# Technical Assessment by the NSW Office of Water for the Minister for Lands and Water

## West Muswellbrook Project – Application for Gateway Certificate

To provide comment on the West Muswellbrook Coal Project, in accordance with the NSW Aquifer Interference Policy, with consideration of the advice of the Independent Expert Scientific Committee (IESC).

Figure 3-7 Government-mapped highly and less productive aquifers within the PAA and surrounding locality (adapted from McAlister and Dvoracek, 2014)

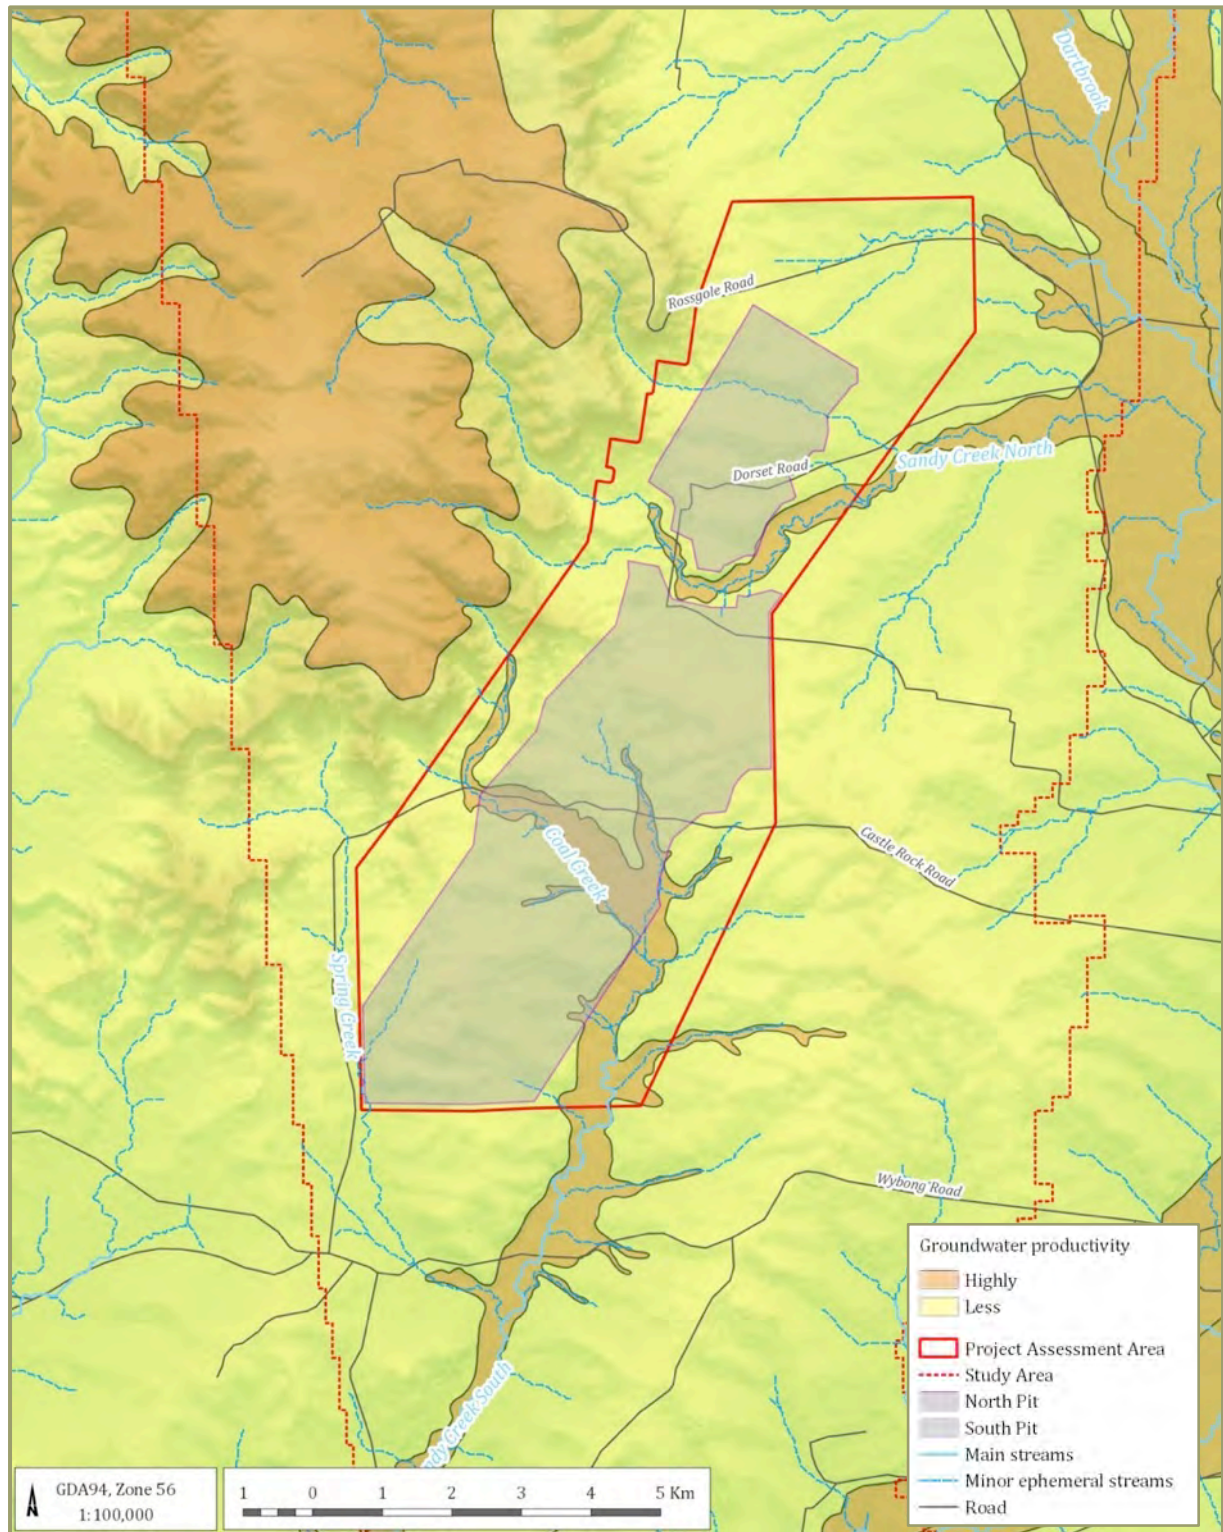
- The proposal will mine a section of alluvium forming part of the highly connected system as part of the Muswellbrook Water Source. Further assessment against the AIP 10% cumulative excavation limit will need to be undertaken. It is noted however that the salinity within the alluvium of Sandy Creek South is indicated to be already elevated with salinity ranging between 4293  $\mu\text{S}/\text{cm}$  to 6575  $\mu\text{S}/\text{cm}$ .

- Mining is proposed to pass through the Coal Creek alluvium and replaced with mine spoil, and there is potential this will enhance hydraulic connection between the alluvium and the coal measure post mining.

- There is the potential river bank instability where mining progresses through sections of Coal Creek alluvium. Engineering solutions will need to be investigated during the DA and detailed design project phases to address this.

- 1** The findings of the IESC are supported.
- 2** The proponent must undertake a full assessment against the AIP using the Office of Water's assessment framework.
- 3** Affected water sources (as defined by the relevant water sharing plans) must be identified.
- 4** An adequate conceptual hydrogeological model must be provided.
- 5** The proponent must address the rules of the relevant water sharing plans.
- 6** Further assessment is required in relation to alluvial impacts.
- 7** Further investigation in relation to river bank stability is required.

Figure 4-2 Bores within the Project Assessment Area and immediate surround with a predicted >2 m drawdown (adapted from McAlister and Dvoracek, 2014)

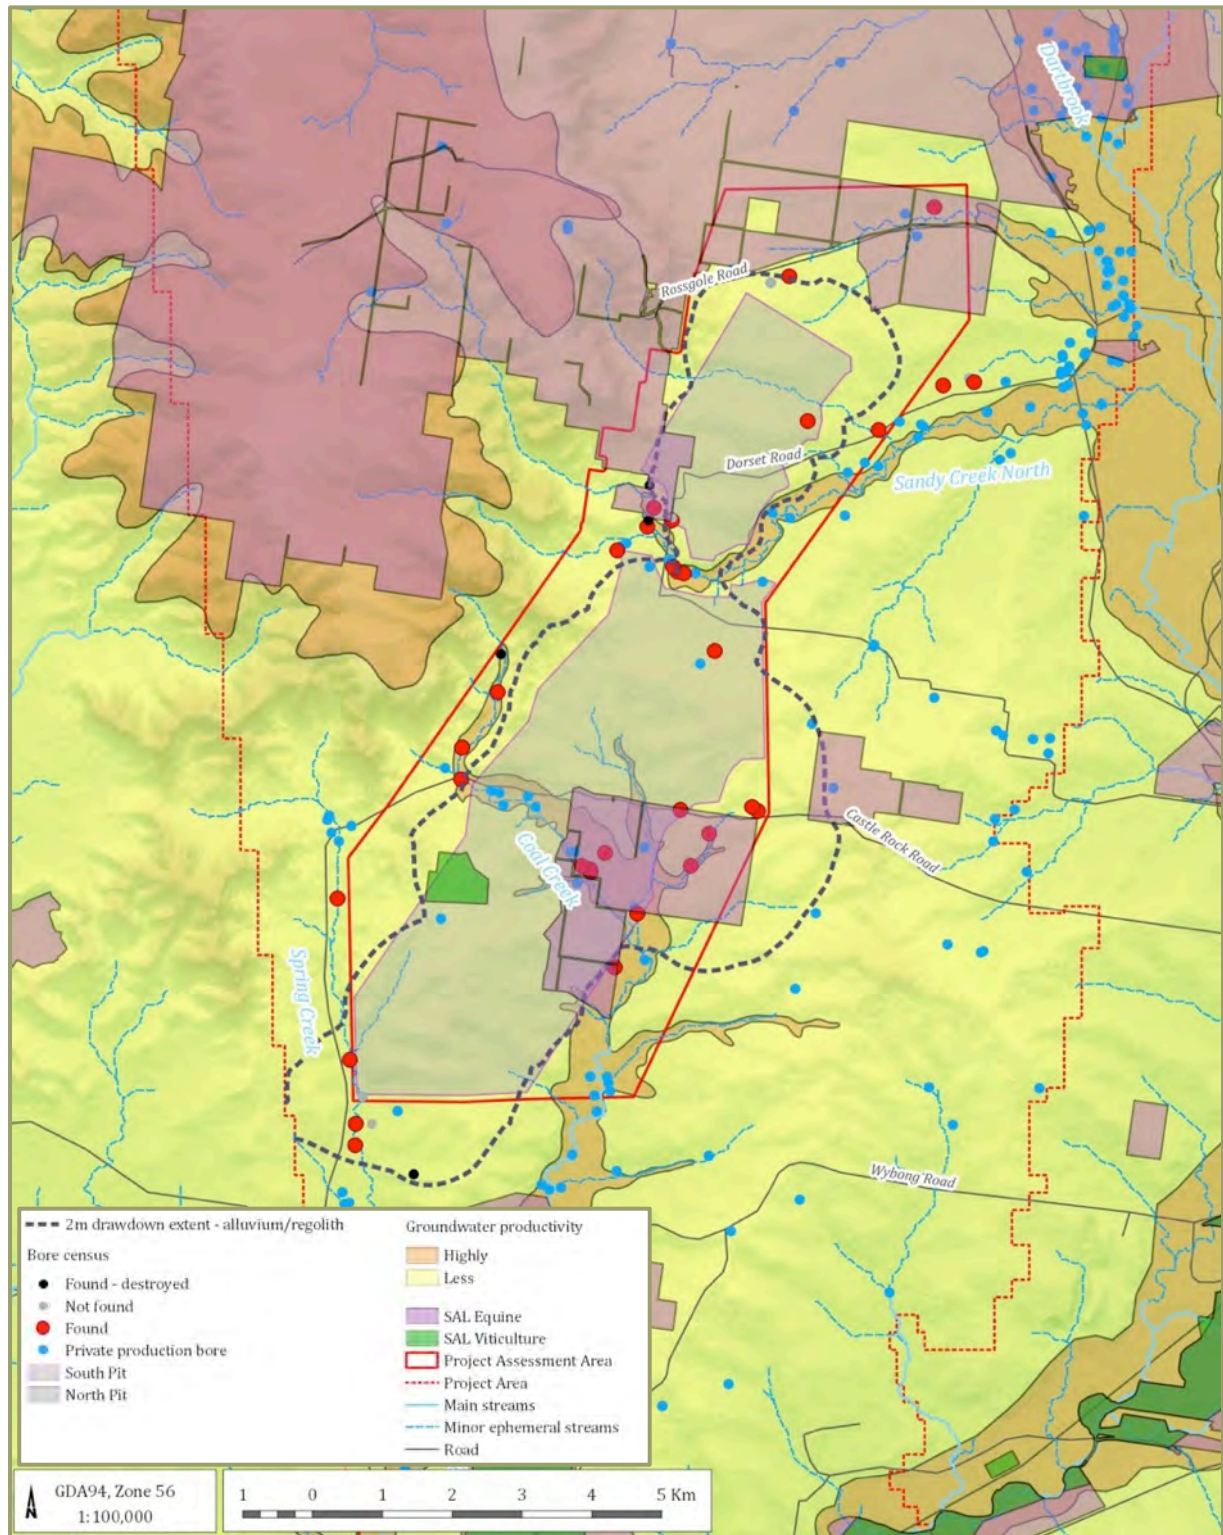
- There are a number of private properties within the mine lease area with groundwater access licences in the highly productive alluvium that are modelled to

have category 2 impact for water level drawdown. The proponent outlines a land acquisition and make good strategy.

minimum defined in the AIP.	
2	A strategy for complying with any water access rules?		WSP rules not reviewed.
3	Potential water level, quality or pressure drawdown impacts on nearby basic landholder rights water users?	The modelling indicates potential for drawdown in a number of private bores to exceed the Level 1 minimal impact considerations. Further studies will be undertaken during the DA phase to improve the accuracy of the model predictions. If predictions are confirmed by future monitoring data, the proponent will consider purchasing the land or entering into a 'make good agreement' with landowners.	Groundwater users impacted by the development have been identified.
4	Potential water level, quality or pressure drawdown impacts on nearby licensed water users in connected groundwater and surface water sources?	Table 5-4 shows 19 bores within highly productive alluvium that are predicted to have drawdowns greater than 2.0 m. 12 of these bores are situated along Coal Creek and are proposed to be removed by mining. The maximum drawdown at the seven remaining bores is predicated to between 2.0 m to 5.9 m.	Groundwater users impacted by the development have been identified.
